CDS is requesting comments on the following short plat application: SP-26-00004
Moulton.

To: All Staff
From: Environmental Health
Date: 6/18/2026
Subject: SP-26-00004 Moulton

TO: All Staff
FROM: Public Works Plan Review Team
DATE: June 22, 2026
SUBJECT: SP-26-00004 Moulton

SUBJECT: WDFW COMMENTS ON MOULTON SHORT PLAT (SP-26-00004)

## Critical Areas

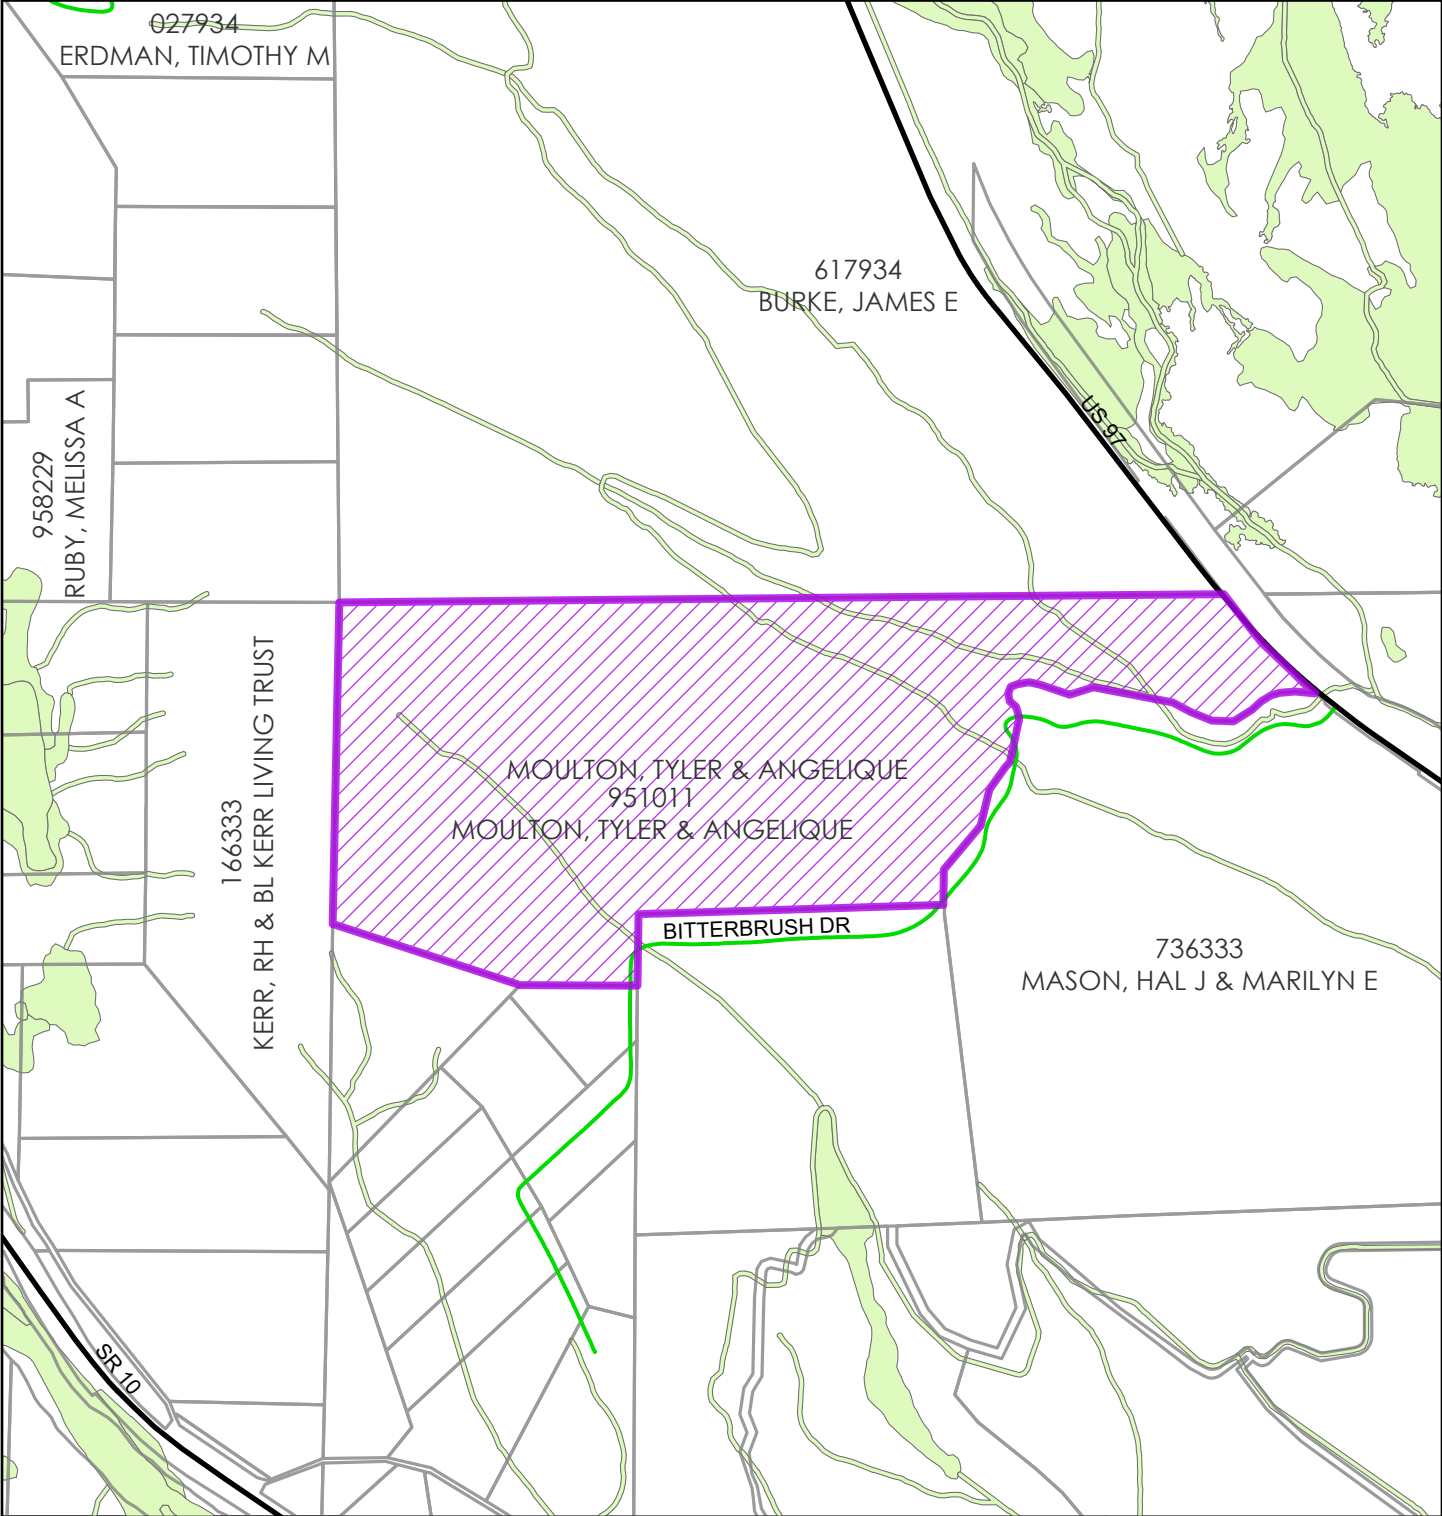
WDFW recommends that these critical areas be included in the Critical Areas Map provided with the application materials and/or as part of the final plat approval. Providing clarity now on the critical areas present will help ensure all future development proposals are aware of these critical areas and the appropriate mitigation measures will be applied to address any potential impacts to shrubsteppe habitat. Future development on these lots should follow mitigation sequencing to minimize disturbance and mitigate for the unavoidable impacts.

MOULTON SHORT PLAT
PART OF SECTION 1, T. 18 N., R. 17 E., W.M.
KITITAS COUNTY, WASHINGTON

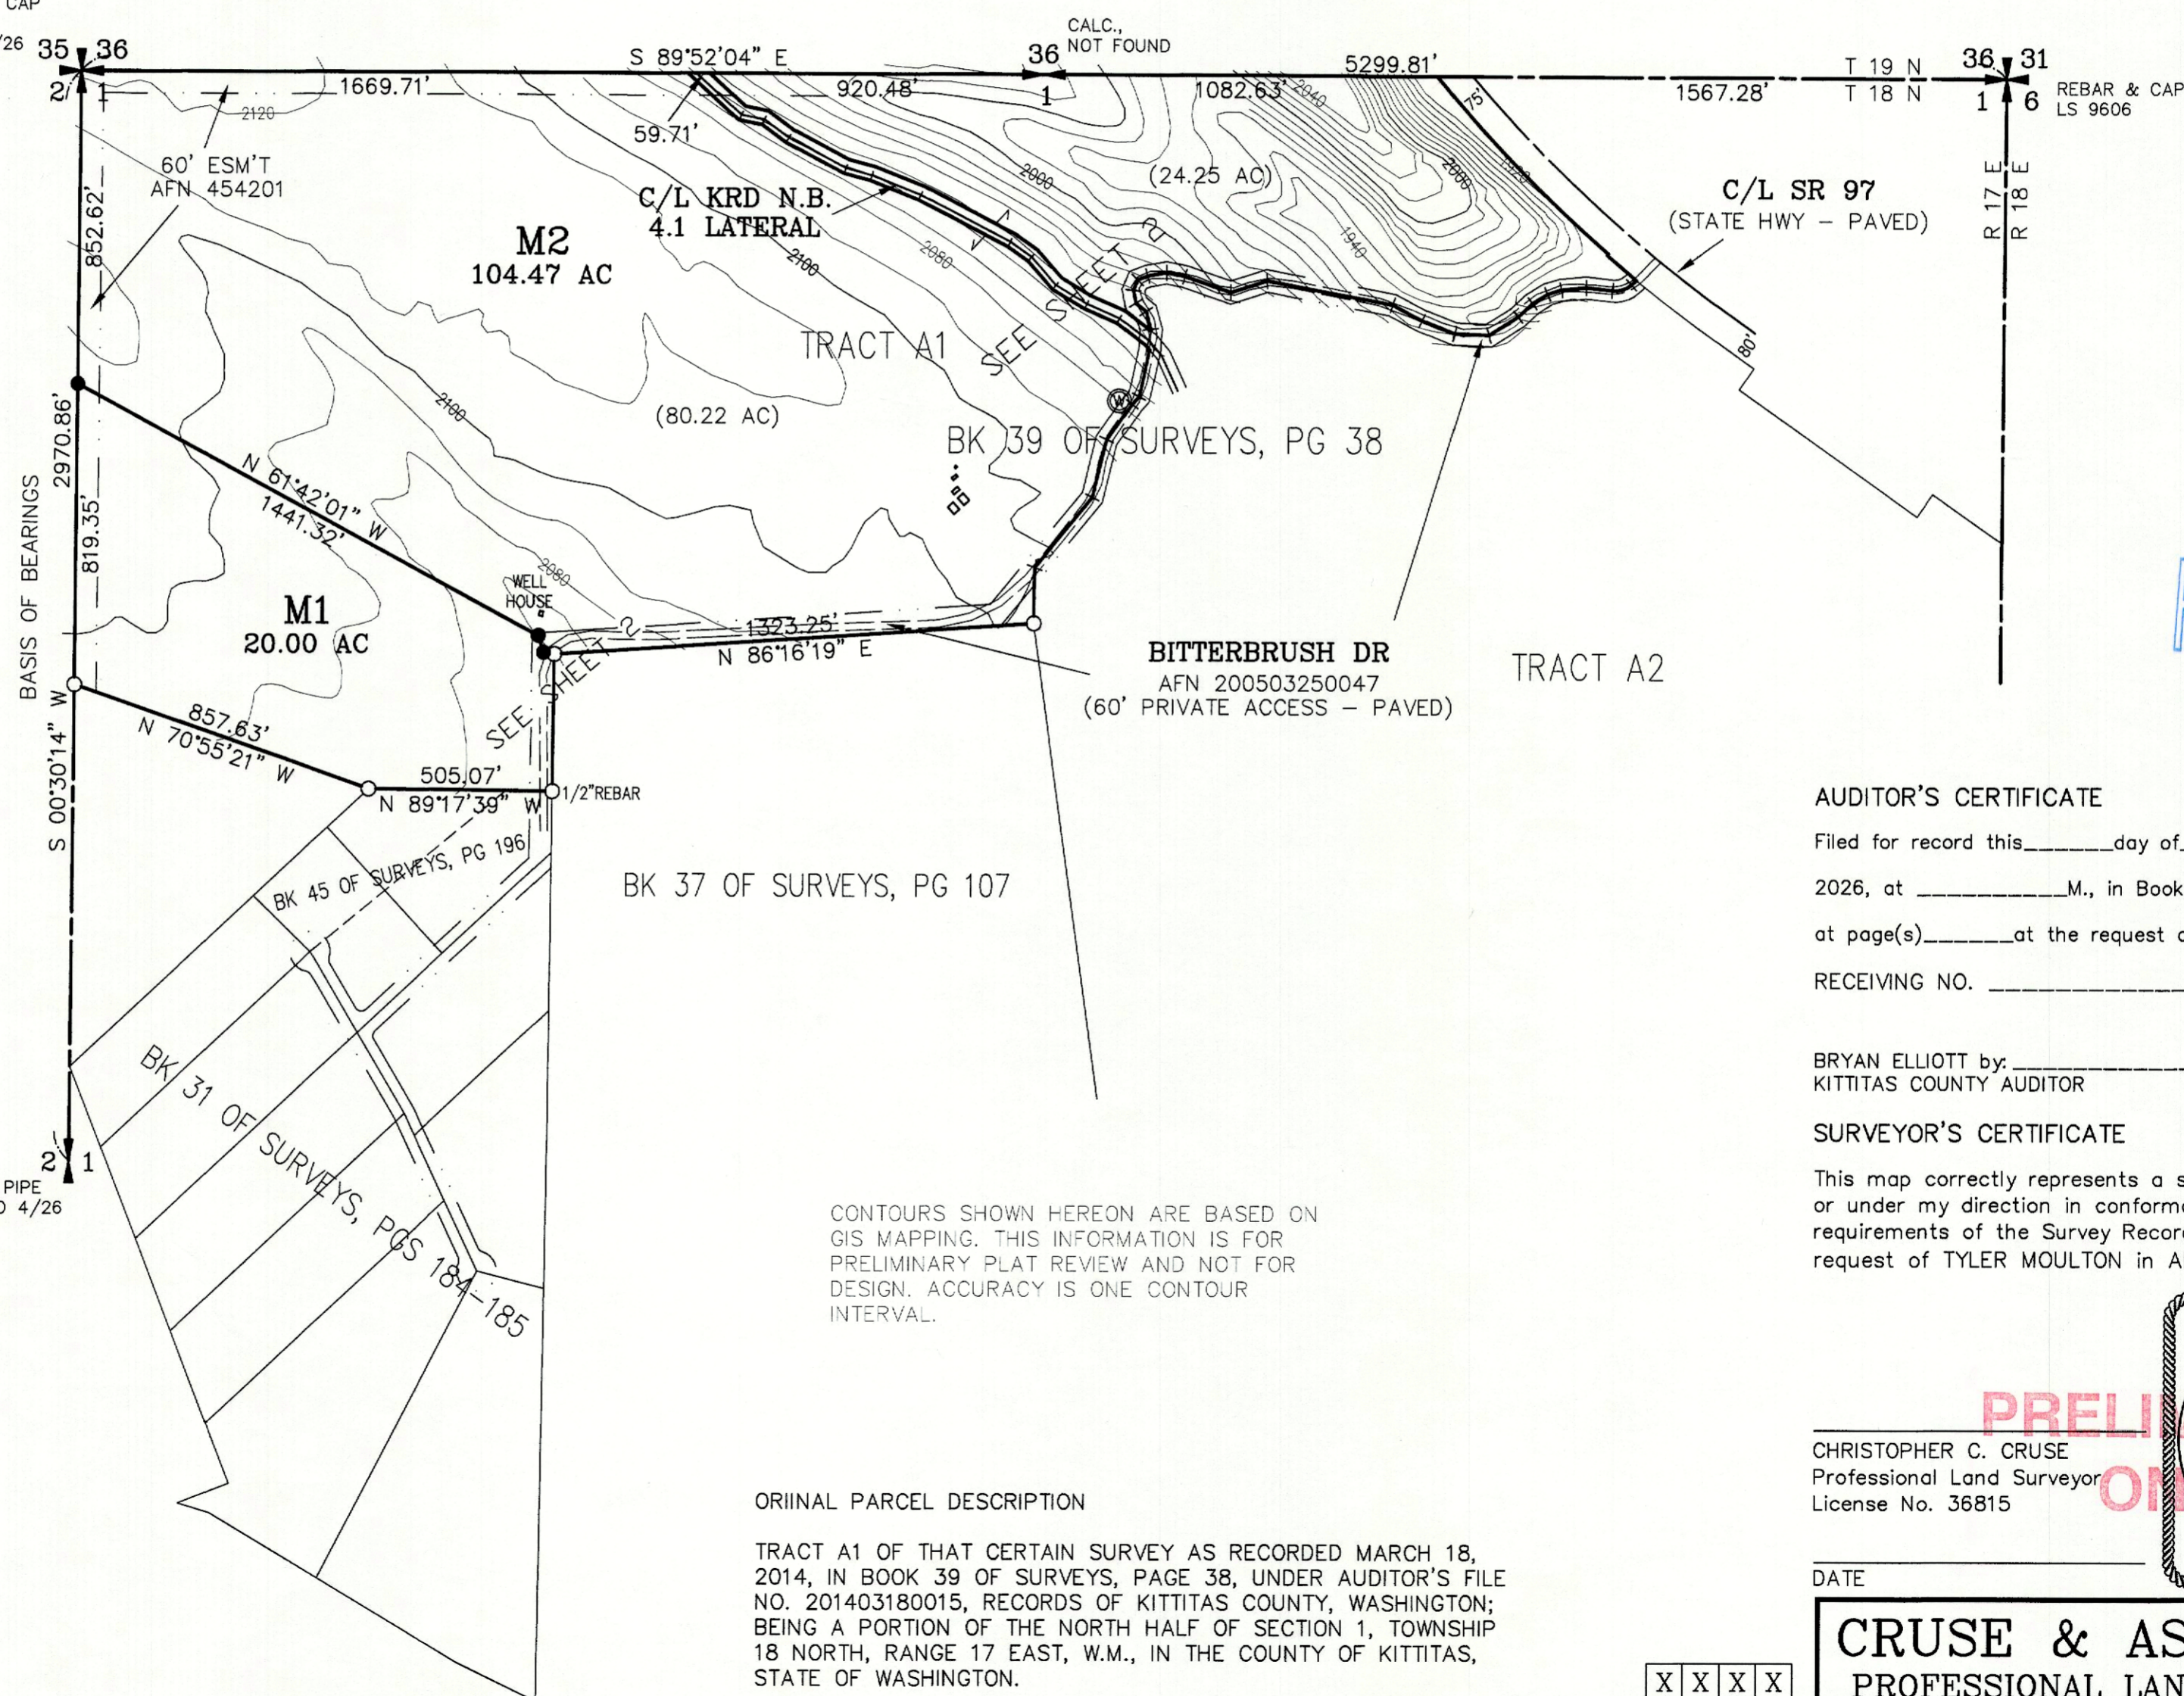
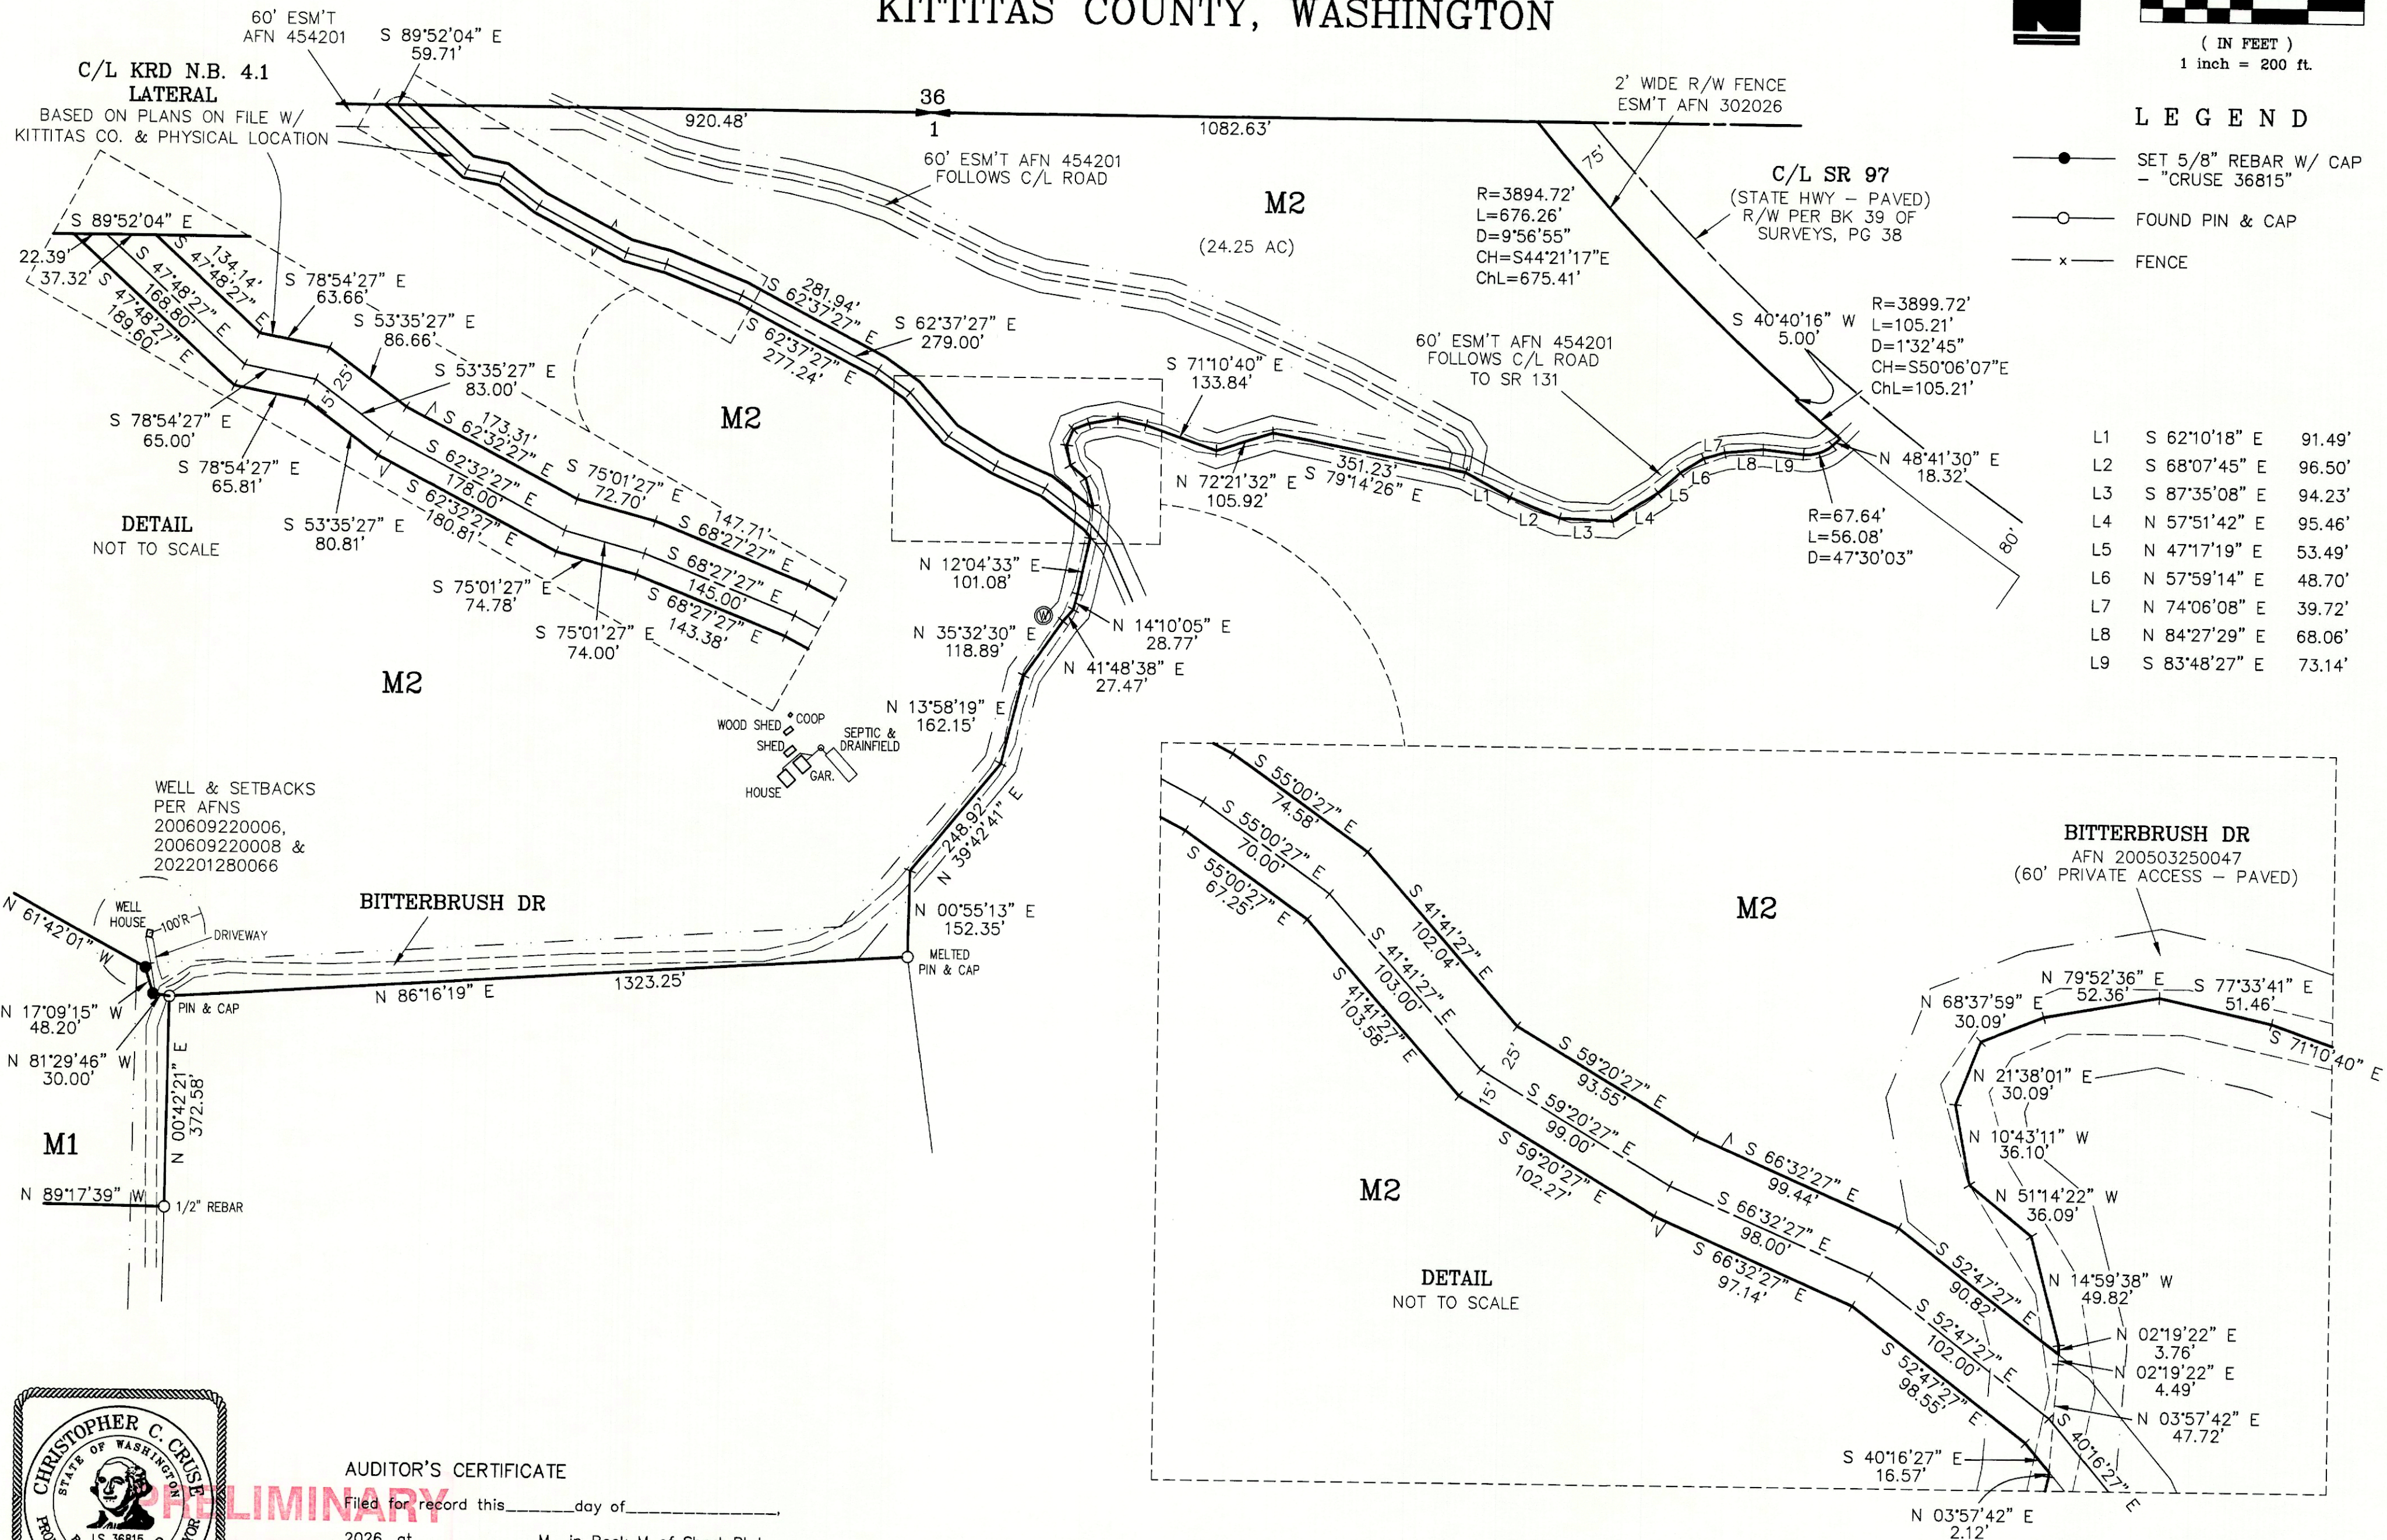
Wastewater	• Prior to preliminary plat approval, the applicant shall perform soil logs in accordance with KCC 13.08.040 to demonstrate that the proposed lots can support conforming on-site sewage systems and required reserve areas. The evaluation shall include a minimum of two soil test pits per lot within the primary and reserve drainfield areas, and the test pit locations shall be shown on the plat map and flagged in the field for inspection.
